Elevation Plans_V1.pdf Markup Summary

6/27/2022 9:39:02 PM (1)

**1 FRONT ELEVATION (NORTHWEST)**  
SCALE: 3/16" = 1'-0"

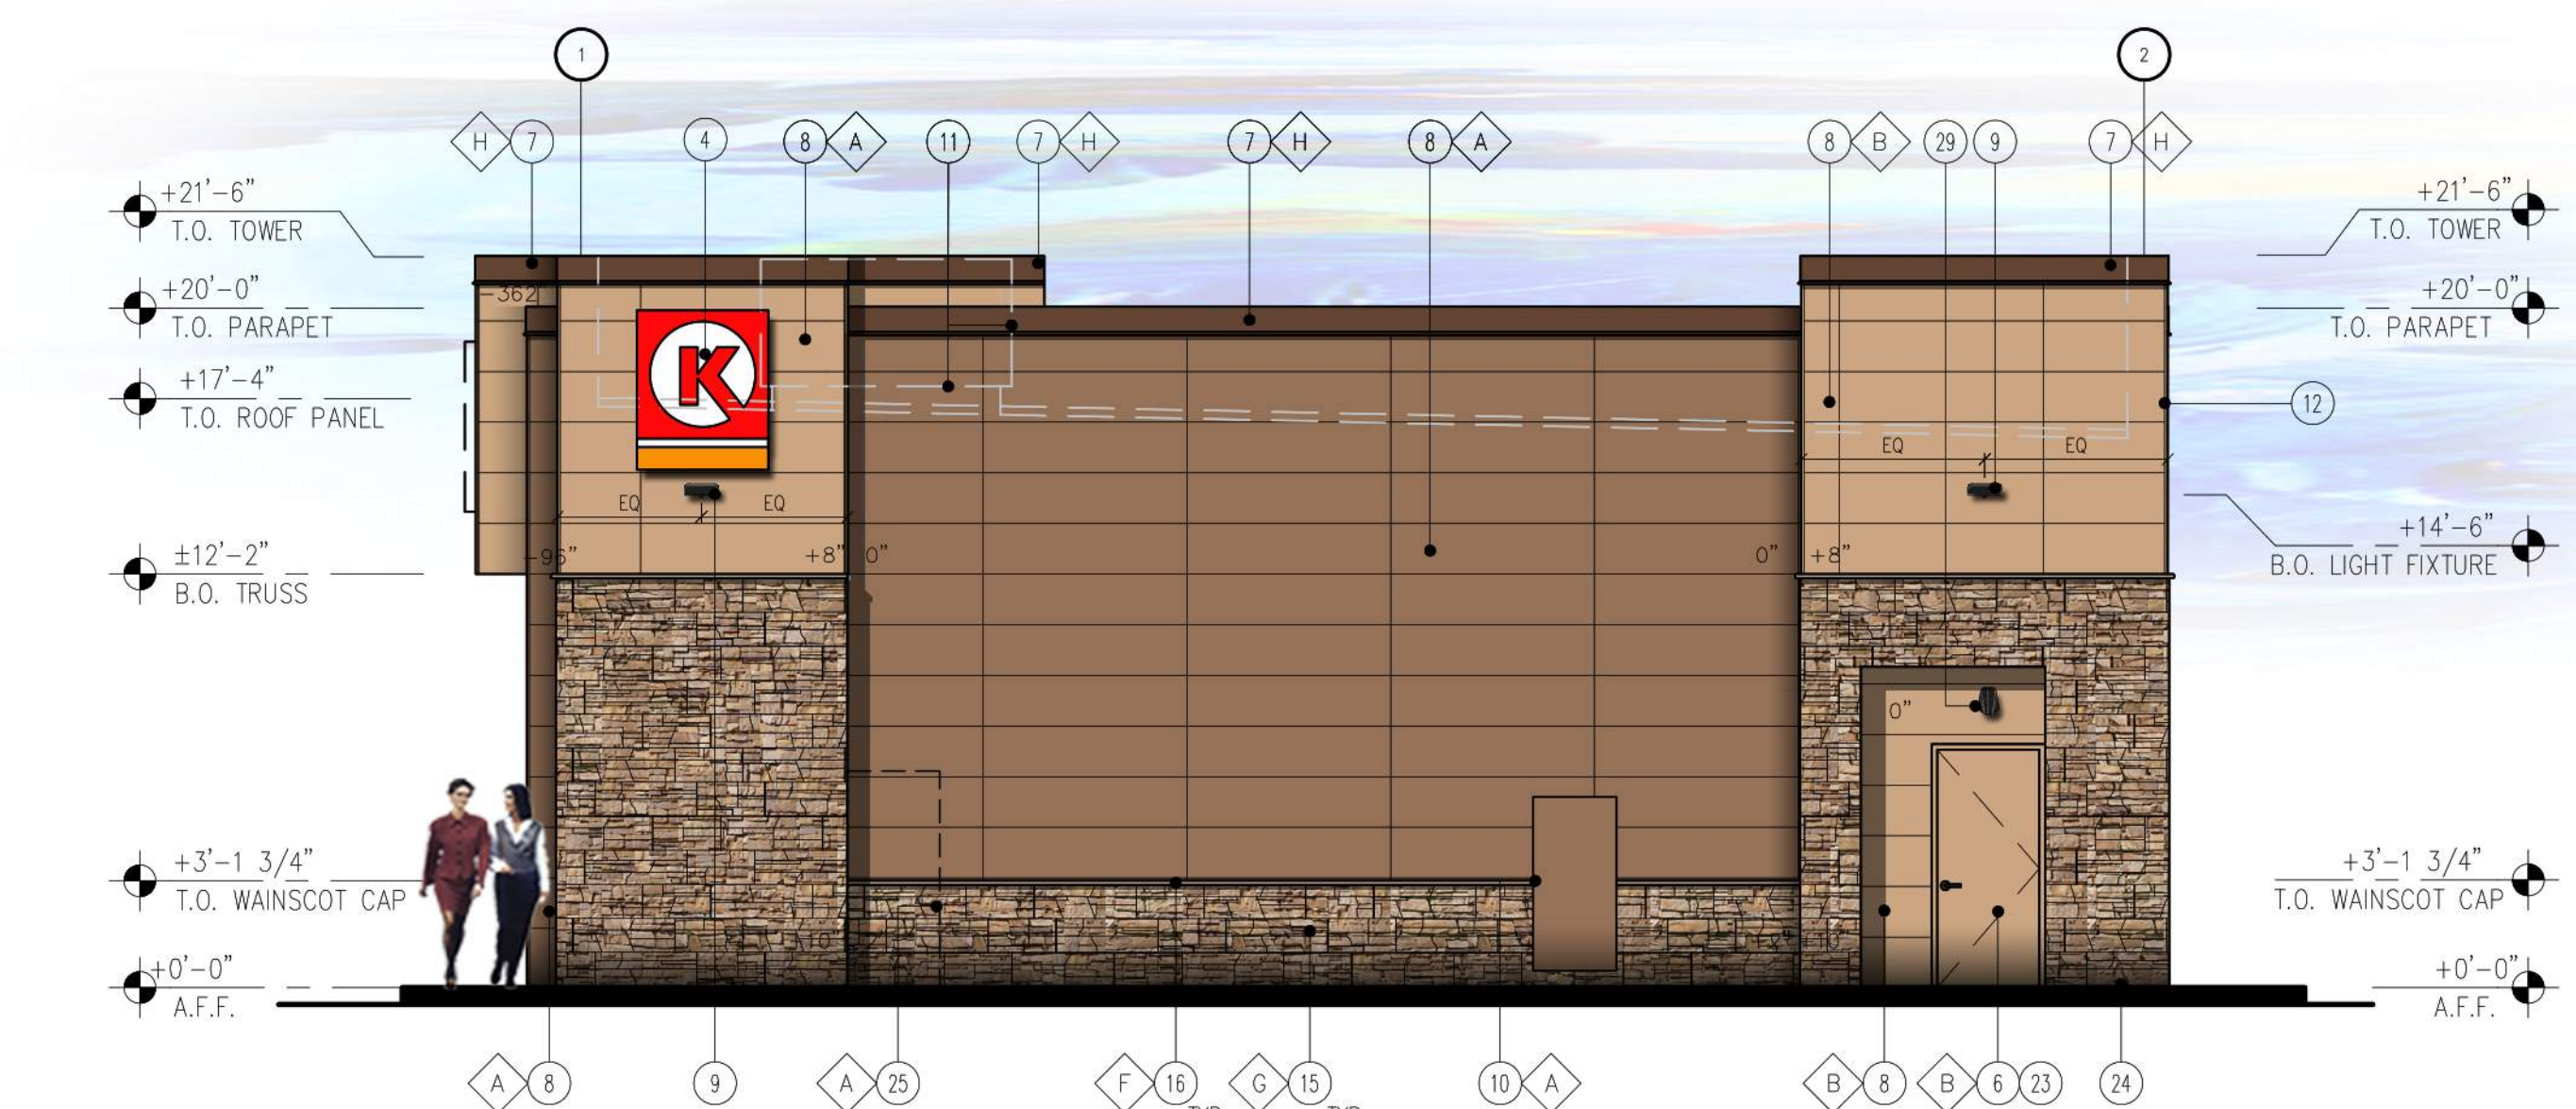
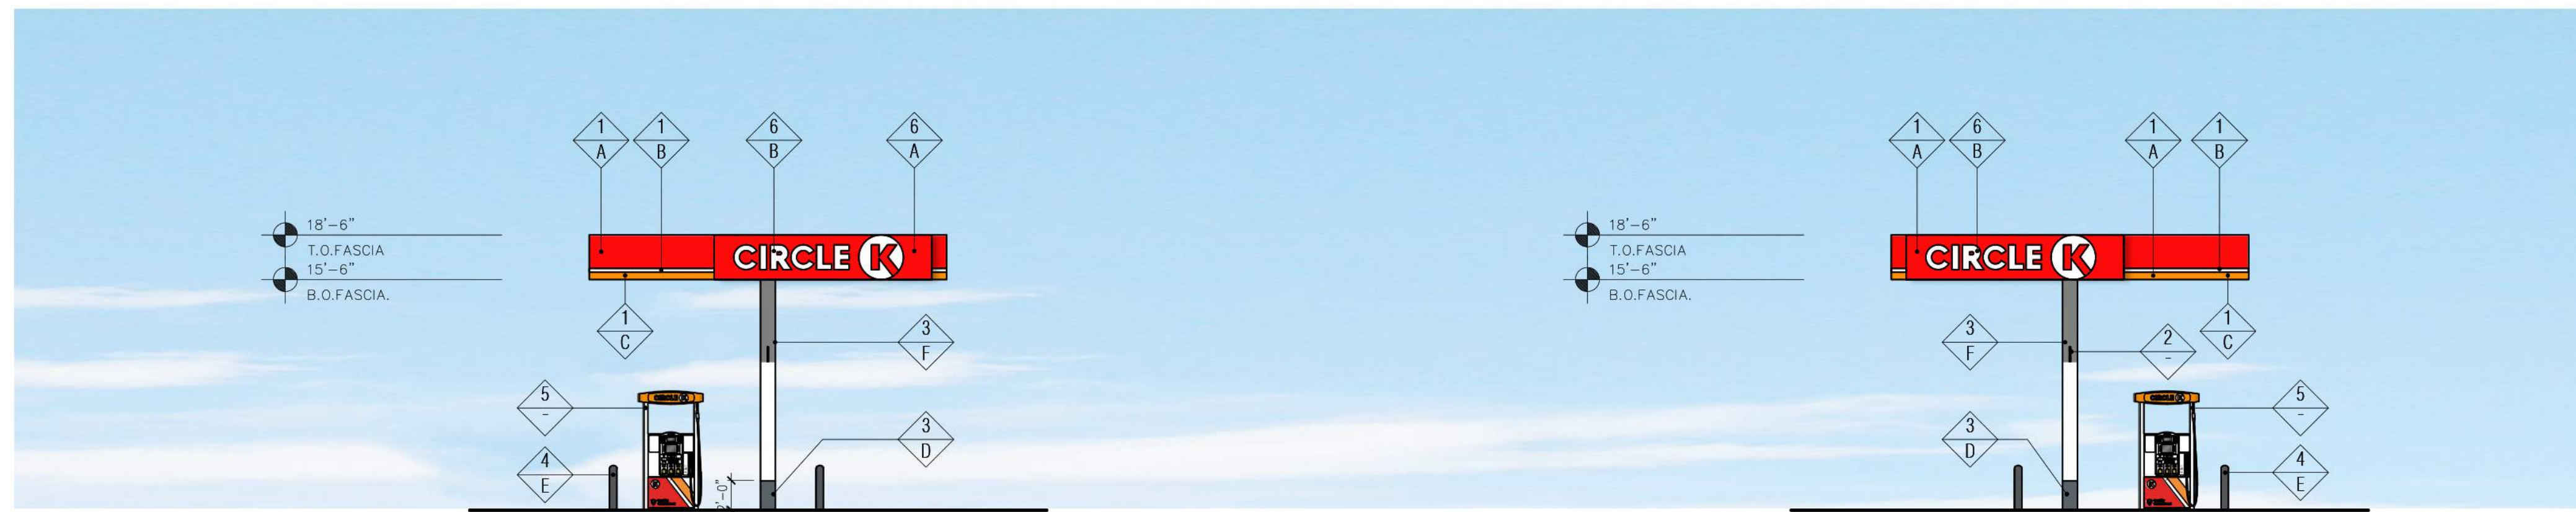
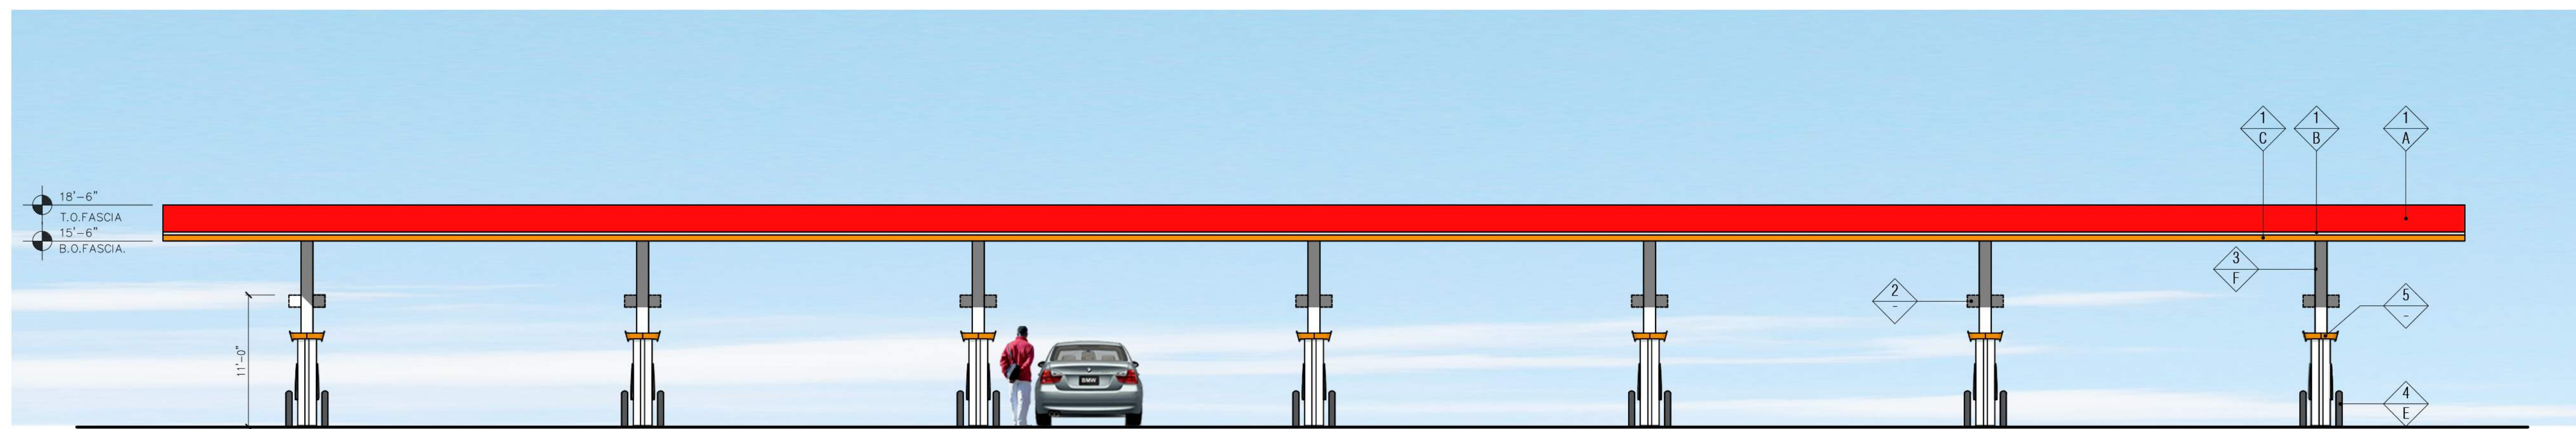
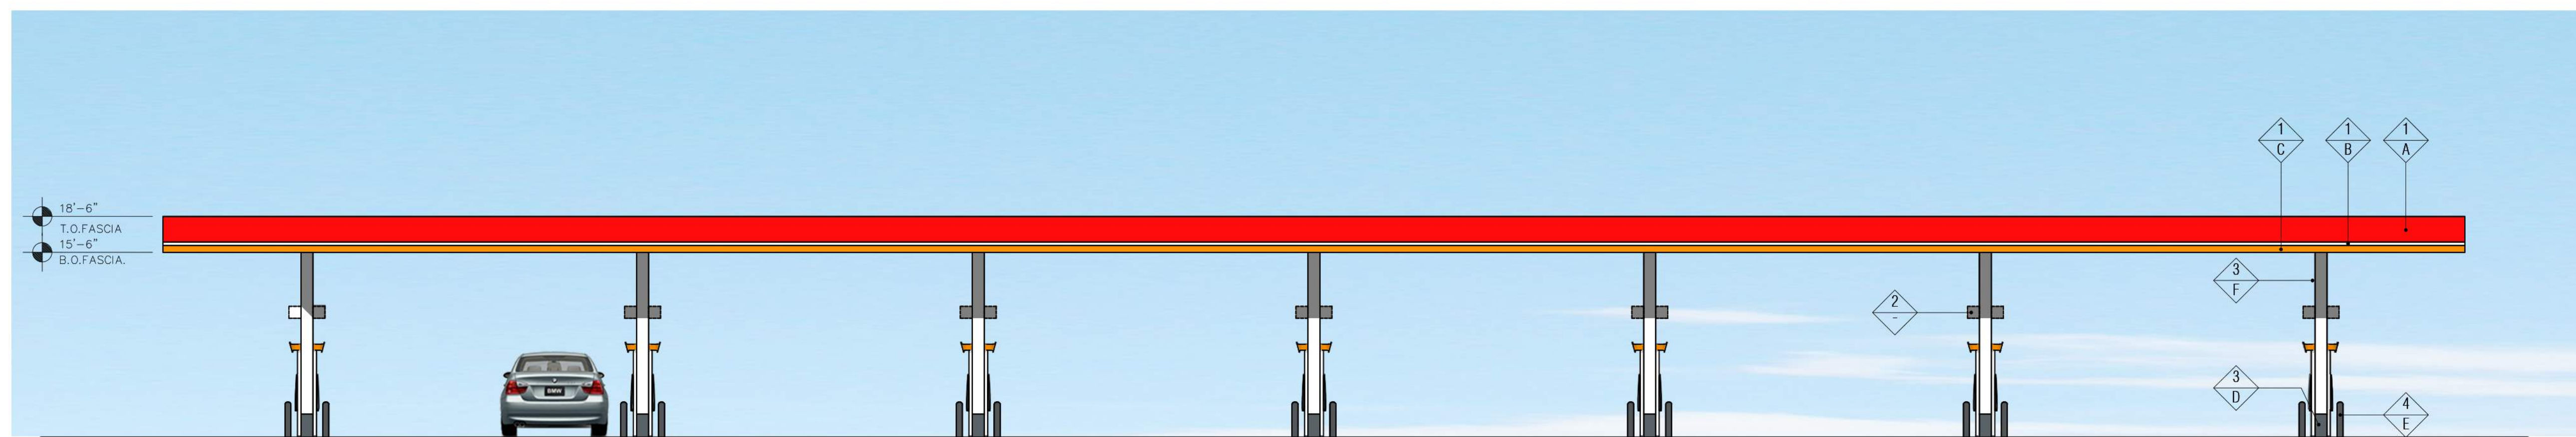
Include Signature block for the Planning and Community Development Director a minimum of 1 inch by 2 inch.

Include Signature block for the Planning and Community Development Director a minimum of 1 inch by 2 inch.

Include Signature block for the Planning and Community Development Director a minimum of 1 inch by 2 inch.
